CITY OF ALBUQUERQUE

June 24, 2019

Re: Restaurant Remodel & Addition
10,000 Coors Blvd NW
30-Day Temporary Certificate of Occupancy
Transportation Development Final Inspection
Engineer's/Architect's Stamp dated 9-17-18 (B14D004D)
Certification dated 6-21-19

DRAWING TITLE:
AMENDED SITE DEVELOPMENT
PLAN

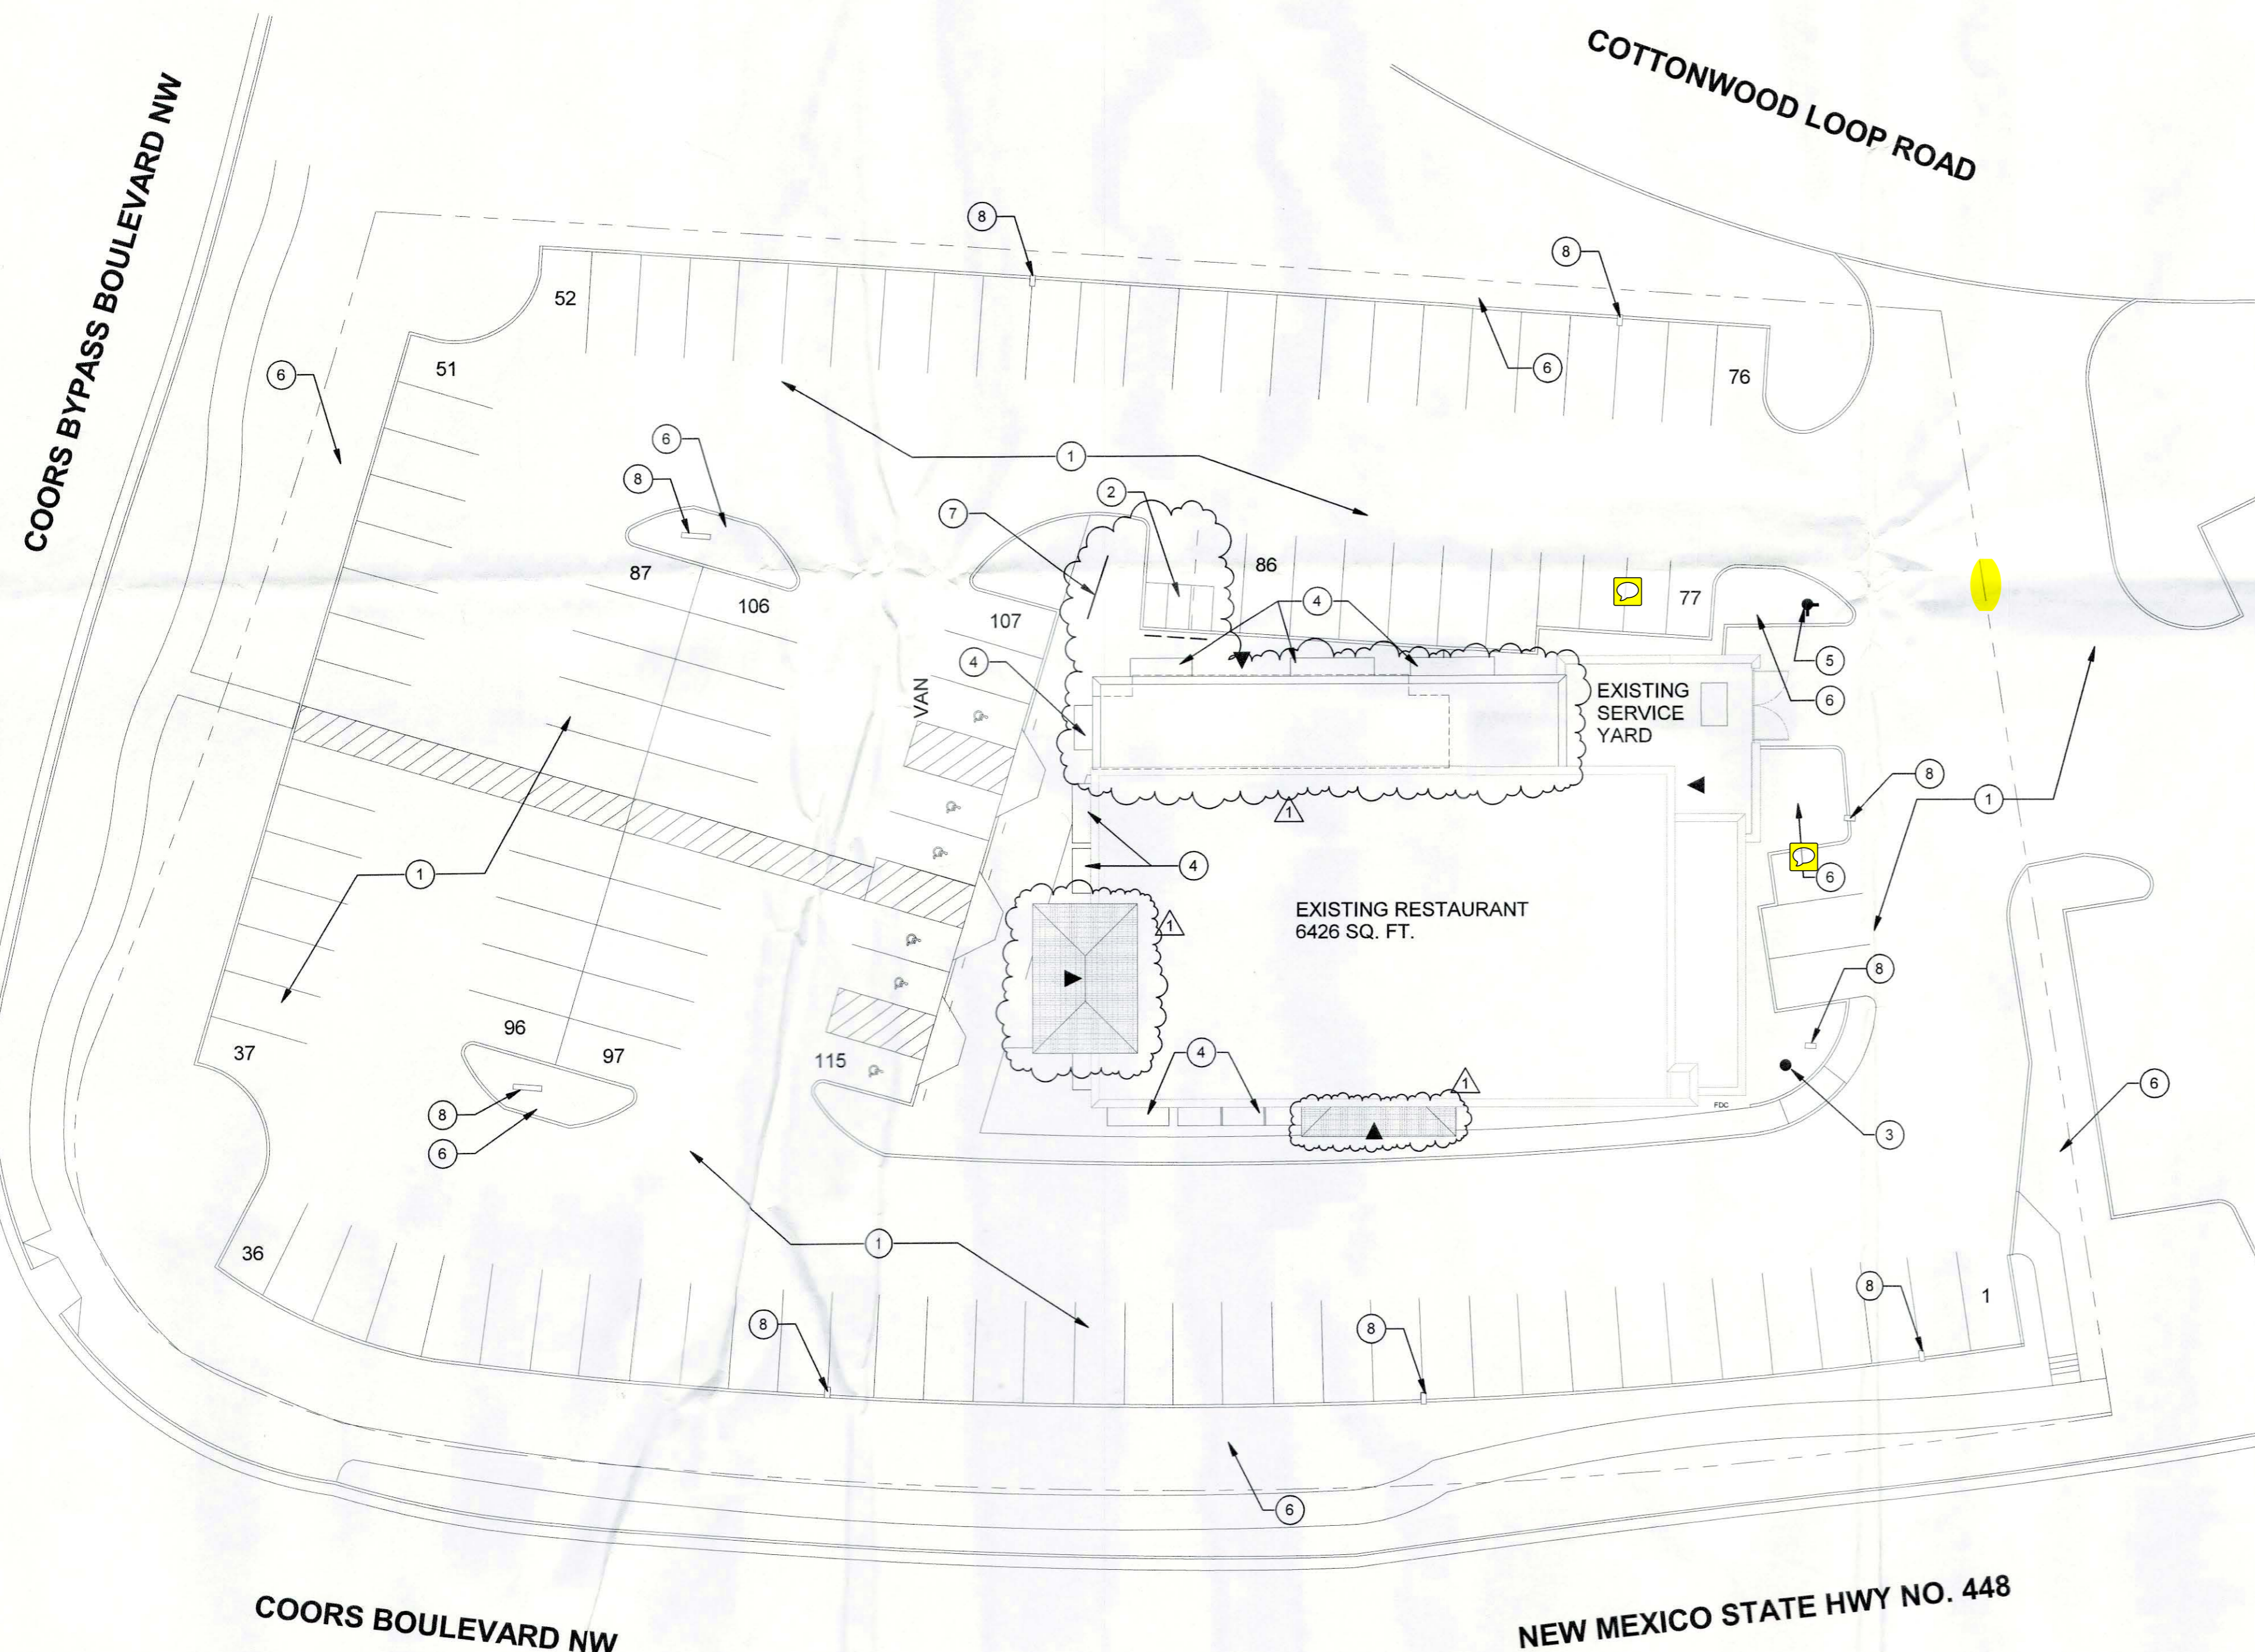
1. Please label the compact parking spaces by placing the words "**COMPACT**" on the pavement of each space. (5 Stalls measured 15 foot in length. See attached plan for locations)
2. Please send photos of corrections to epgomez@cabq.gov for release of final CO.
